**SOUTH DERBYSHIRE DISTRICT COUNCIL’S
ANSWERS TO THE ExA’S THIRD WRITTEN QUESTIONS
FOR DEADLINE 8**

Oaklands Farm Solar Farm NSIP

PINS Reference: EN010122

Figure 1a: Habitat constraints plan

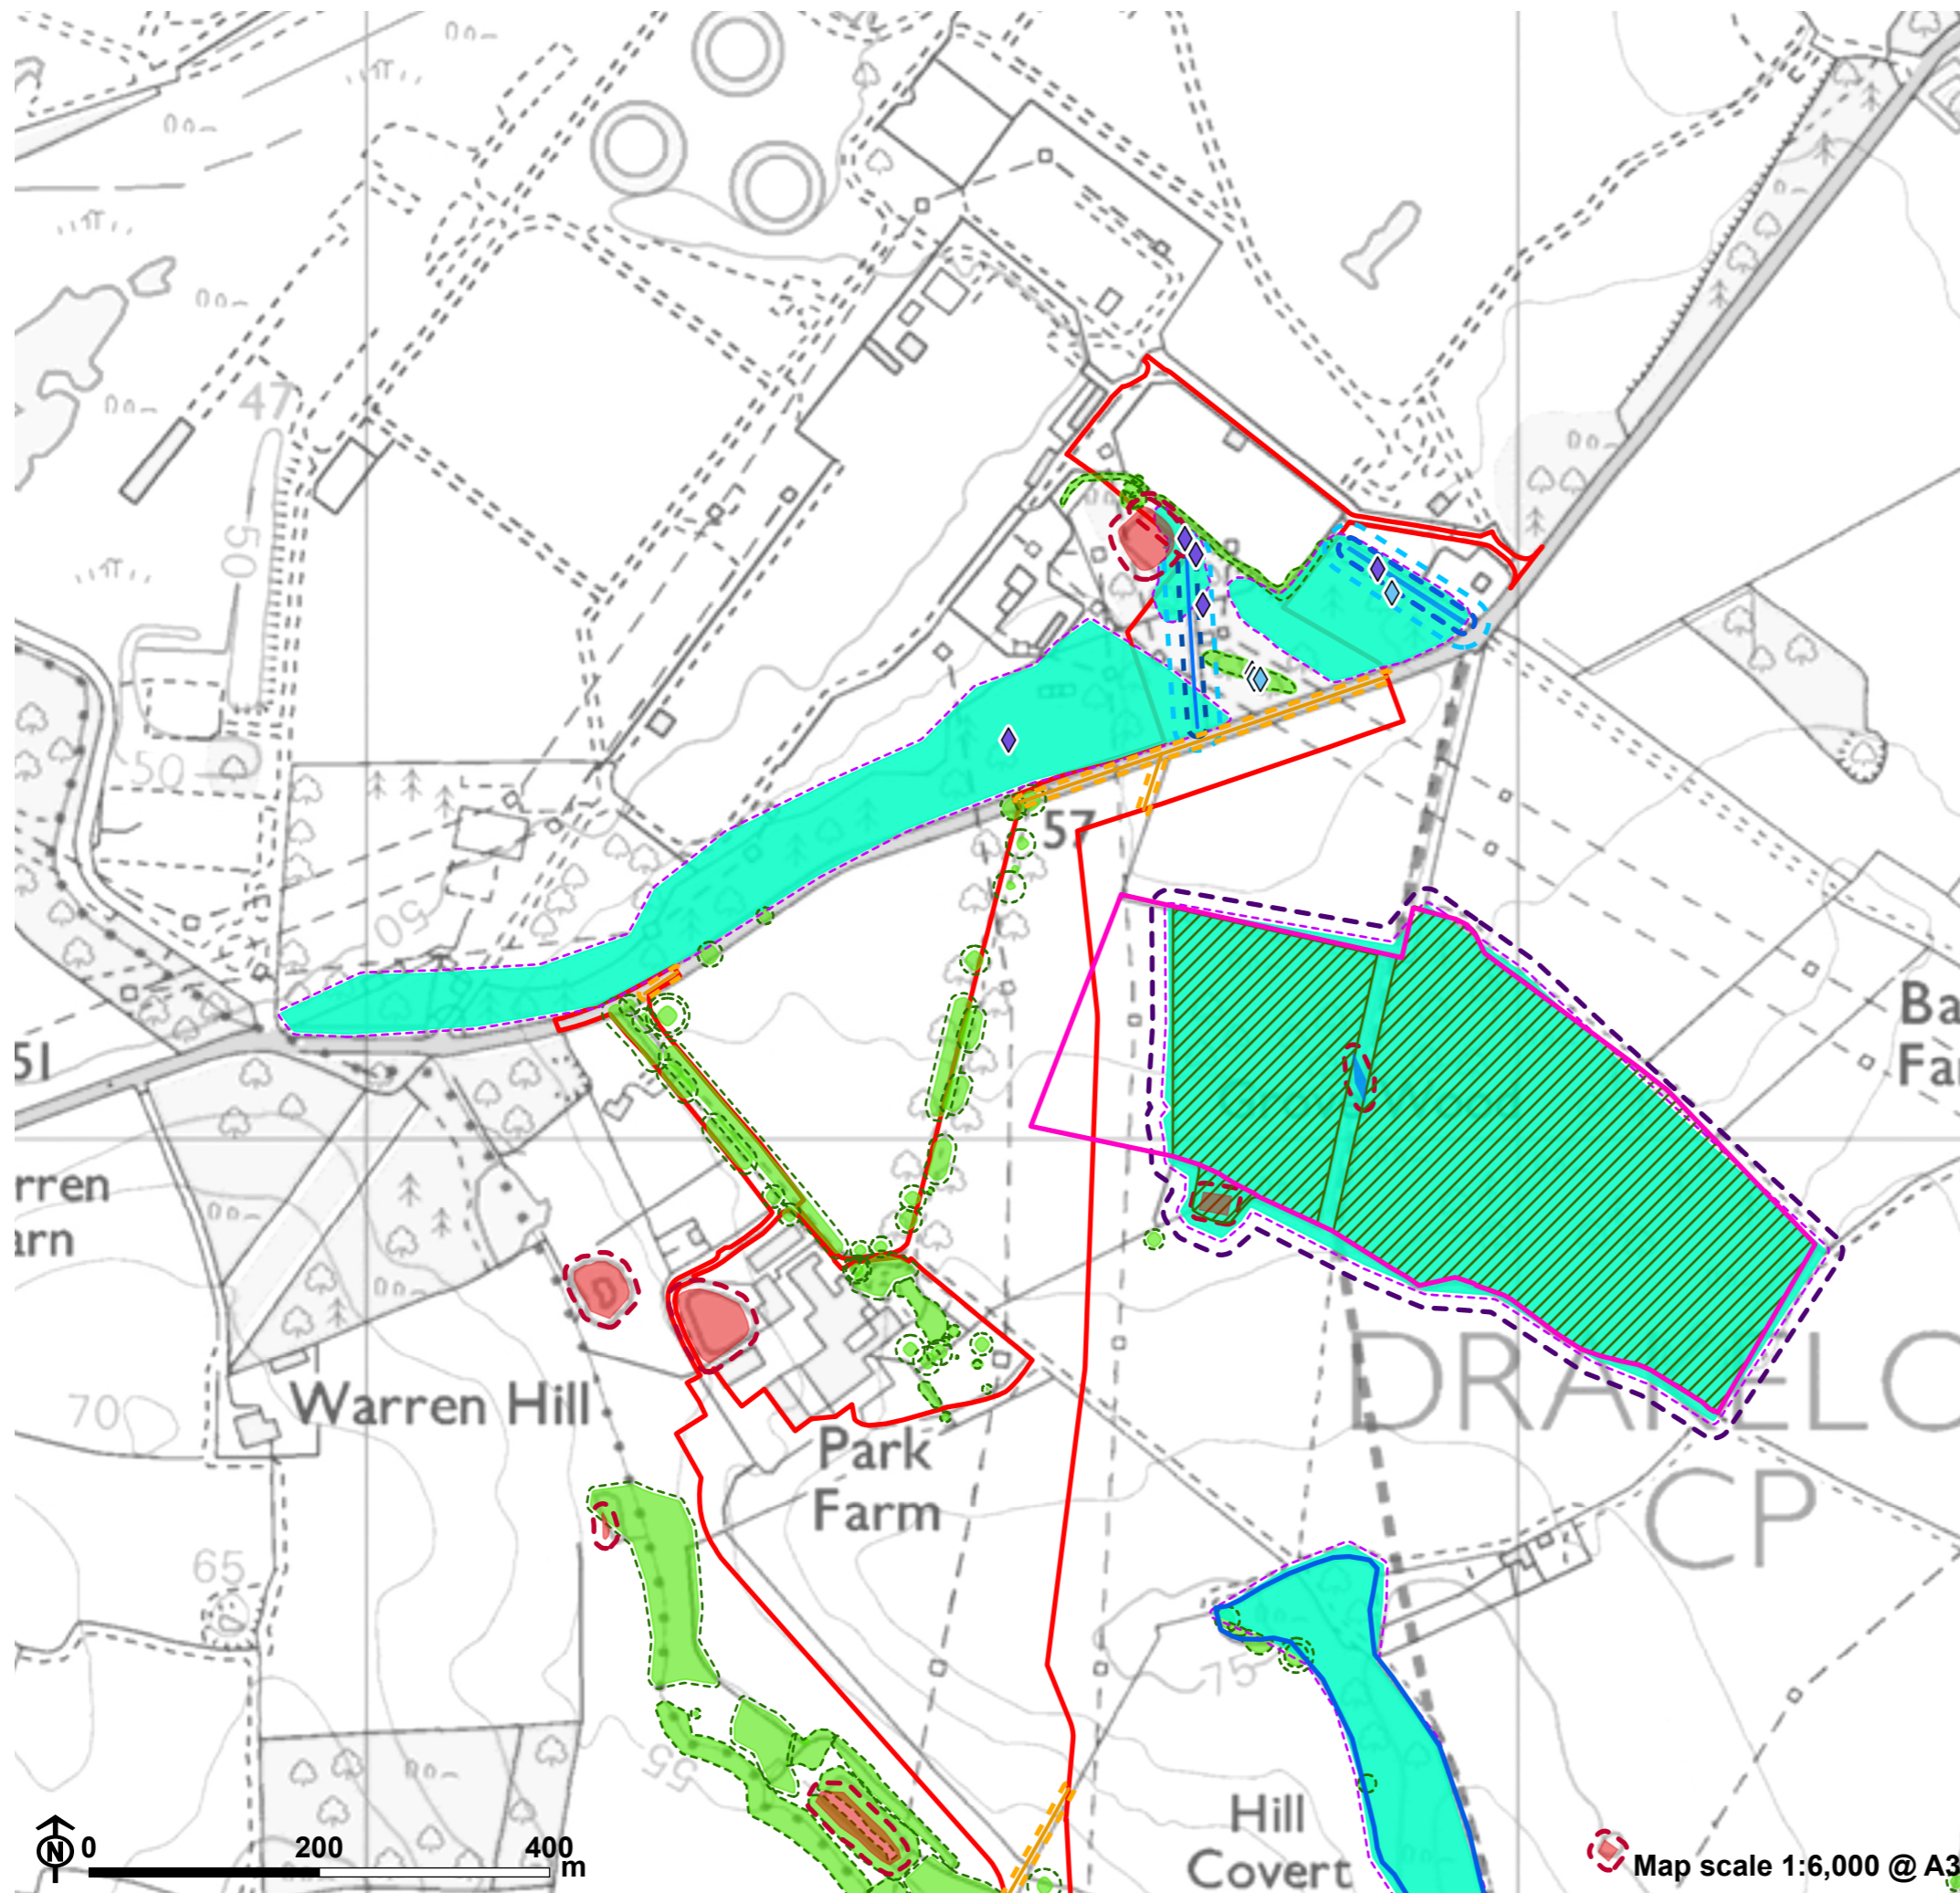
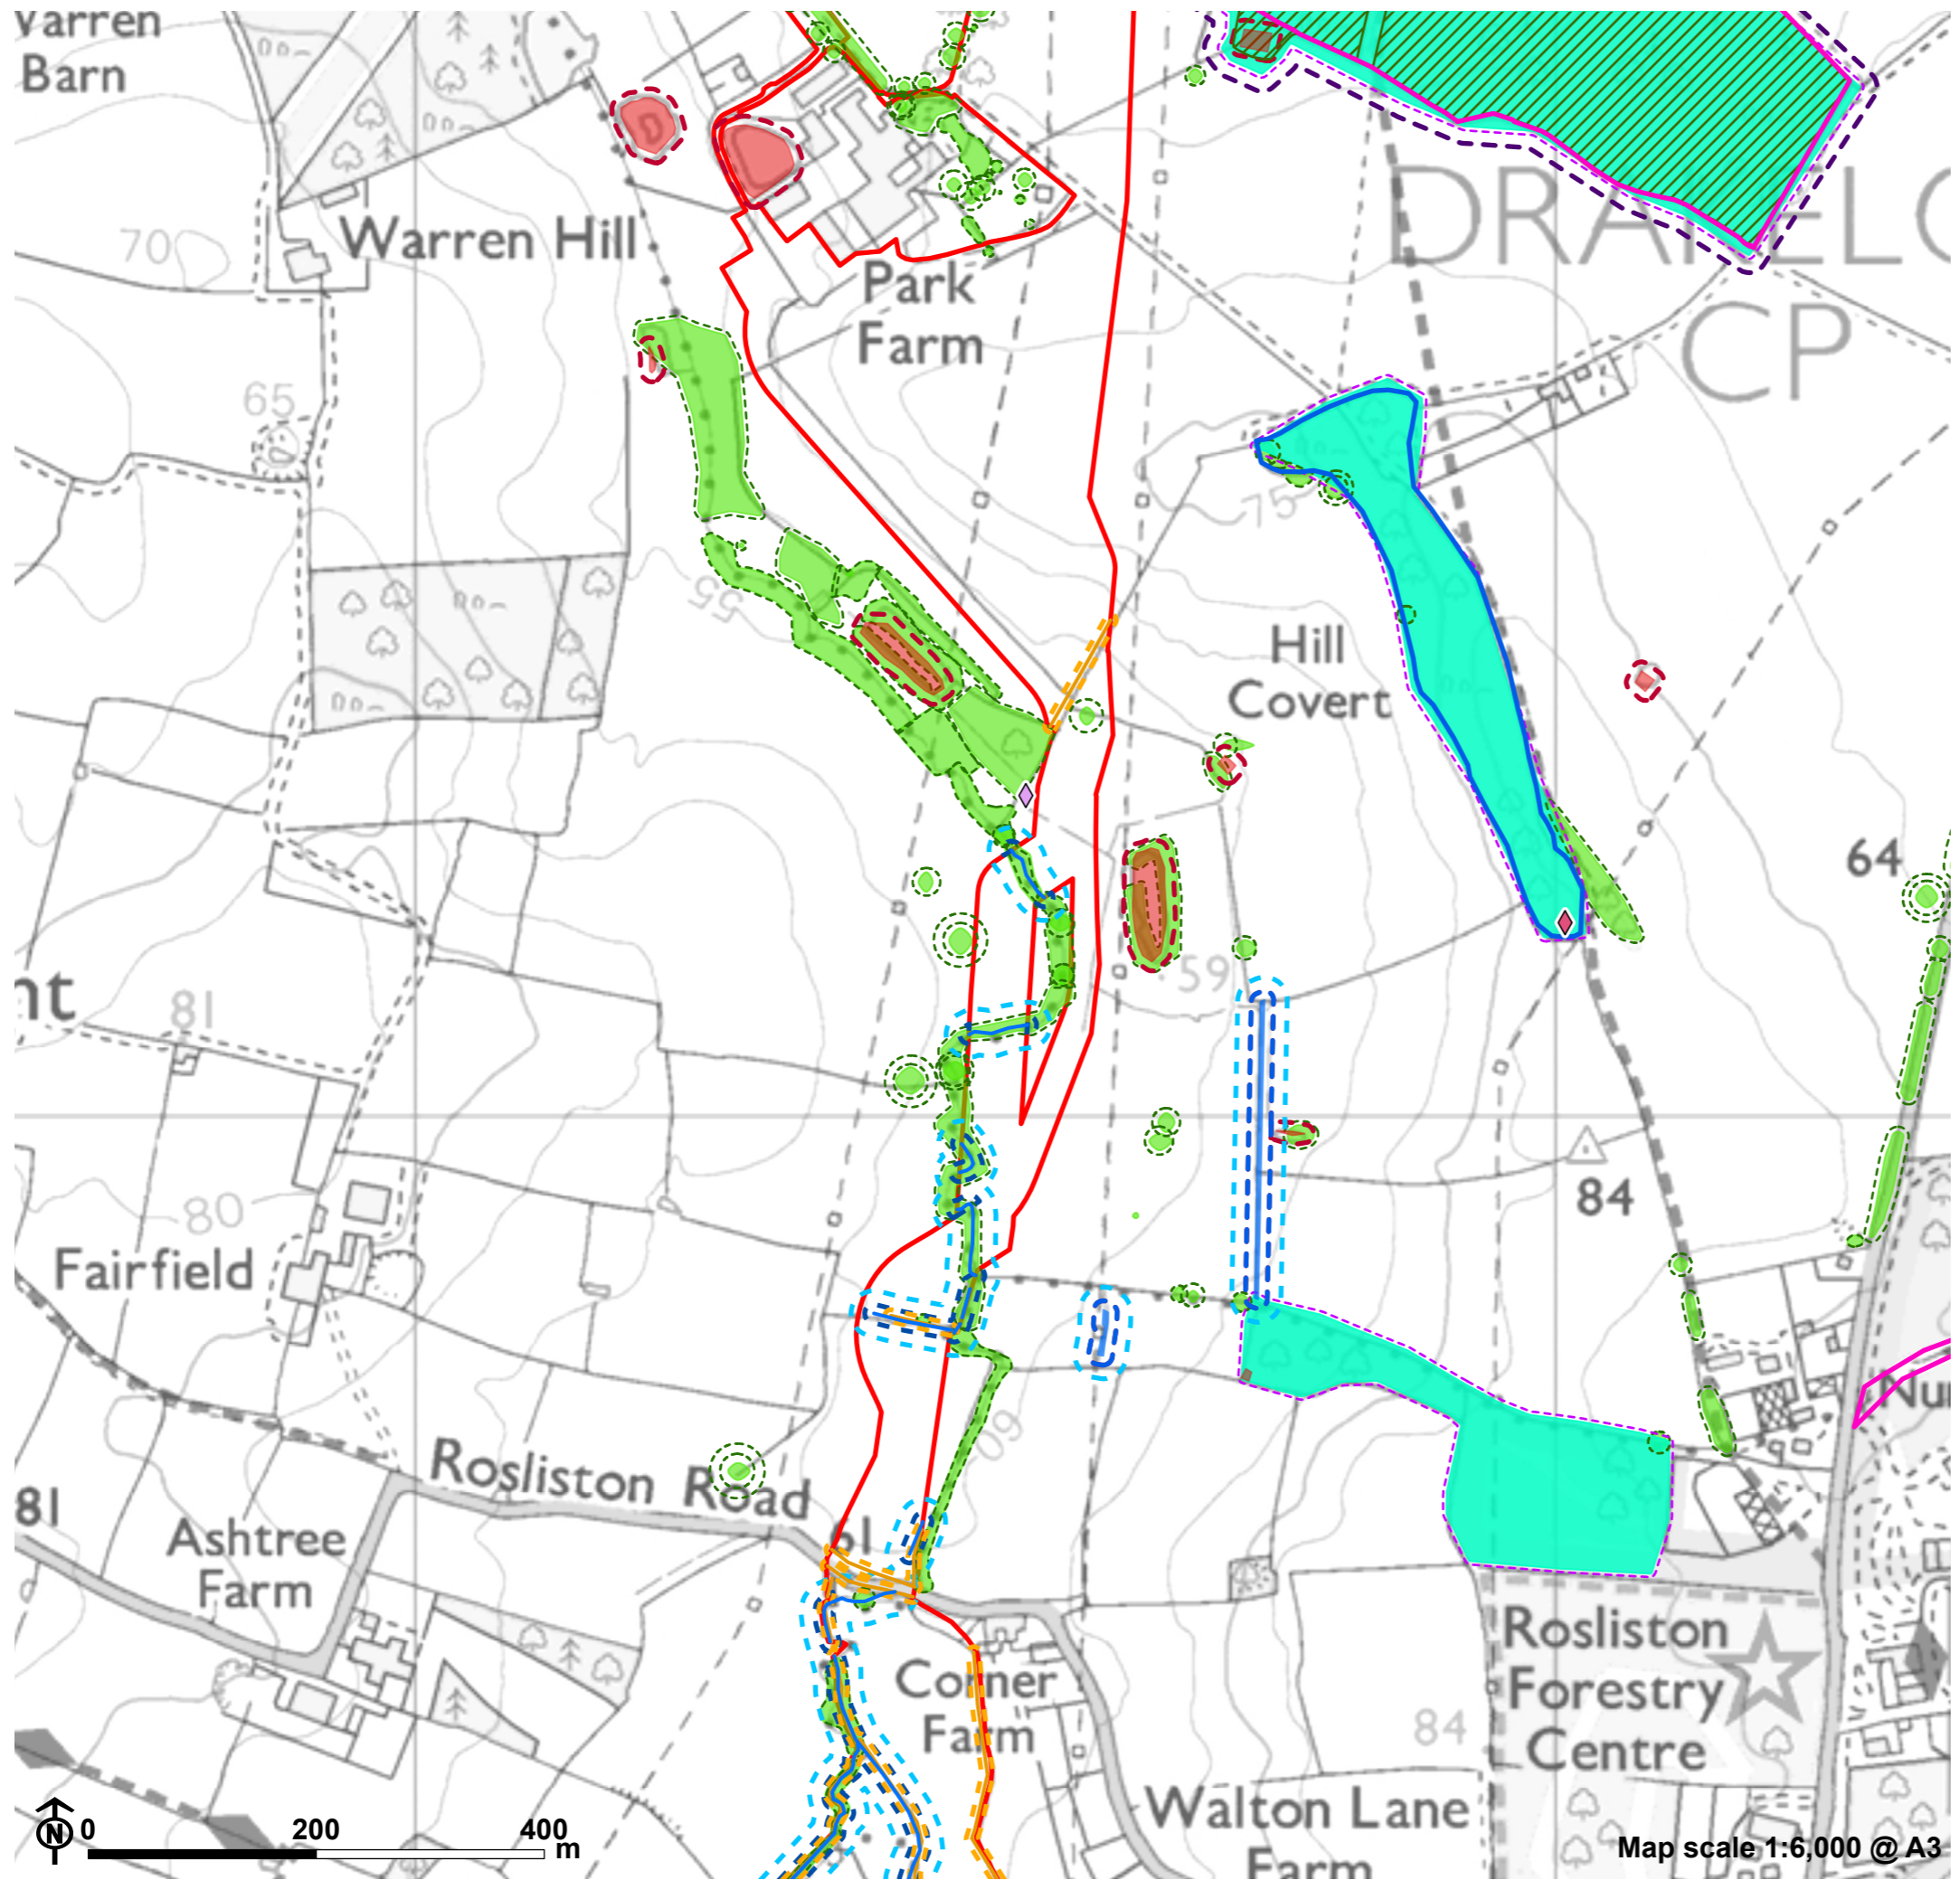
7.3	<p><u>Habitat Constraints Plan</u></p> <p>SDDC [REP4-014] and DCC [REP4-012] referred to the need for a Habitat Constraints Plan with interpretable maps to provide the necessary details and extent of site clearance works relating to buffer zones to sensitive features such as ancient/ veteran trees, other retained trees, ponds, watercourses, hedgerows and woodlands.</p> <p>The Outline CEMP [REP5-011] includes provisions for a Habitats Constraint Plan [Section 2.8.5] and buffers [Sections 2.6.4, 2.6.5, 2.8.2, 2.8.3, 2.8.5, and 2.8.6]. The Applicant provides a series of interpretable maps of habitat constraints [REP5-030].</p> <p>a) Please could the Applicant add the draft interpretable maps to the Outline CEMP [REP5-011] and secure that interpretable maps be included in the final CEMP?</p> <p>b) Please could SDDC and DCC comment?</p>	<p>c) SDDC has no further comments to add in addition to those previously made at Deadline 6, which are repeated below:</p> <p>“SDDC have reviewed those interpretable maps, and they provide useful clarity and should be attached to the Outline CEMP for further comprehensive review.”</p>
